Application for a non-material amendment following a grant of planning permission.

Number	28
Suffix	
Property name	
Address line 1	Sea Drive
Address line 2	
Address line 3	
Town/city	Felpham
Postcode	PO22 7NE
Description of site location must be completed if postcode is not known:	
Easting (x)	496658
Northing (y)	99666
Description

New entrance & double height hallway to front elevation, first floor extension over existing single storey side extension, single storey rear extension with glazed doors to balcony, creation of first floor balcony, single storey rear extension & cladding to entire dwelling.

FP/205/18/HH & FP/46/19/PL

Project: Z0338 Number: AGA-03

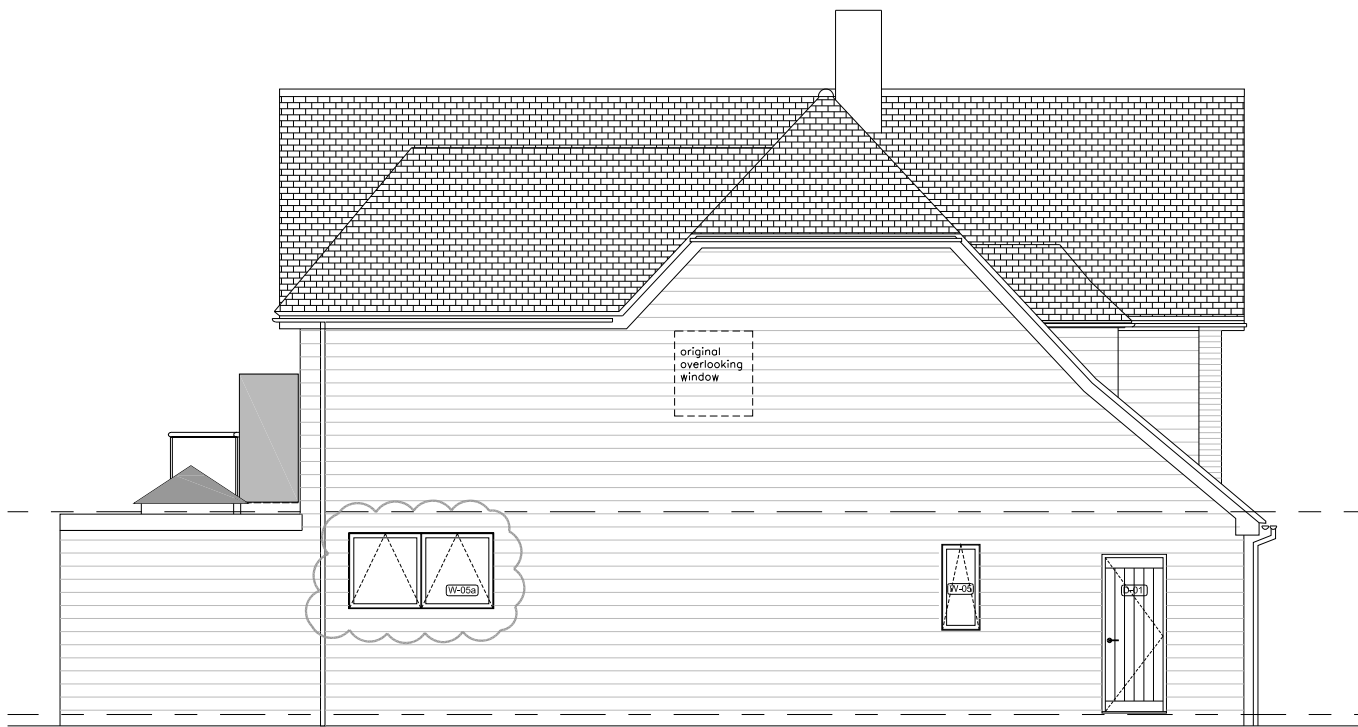
Kitchen window on west elevation

In the course of the building work it has become apparent that the new kitchen lacks daylight. The sill of the proposed window is 1.4m above the internal ground floor level and faces the blank side elevation of no. 27 Sea Drive. It can be seen on site that the window doesn't overlook or intrude on the privacy of the neighbour. The neighbour has in fact benefitted from the closing up of a former window at first floor, which overlooked their garden.

Floor plans Z0338 AGA 01 rev G
Elevations Z0338 AGA 03 rev F
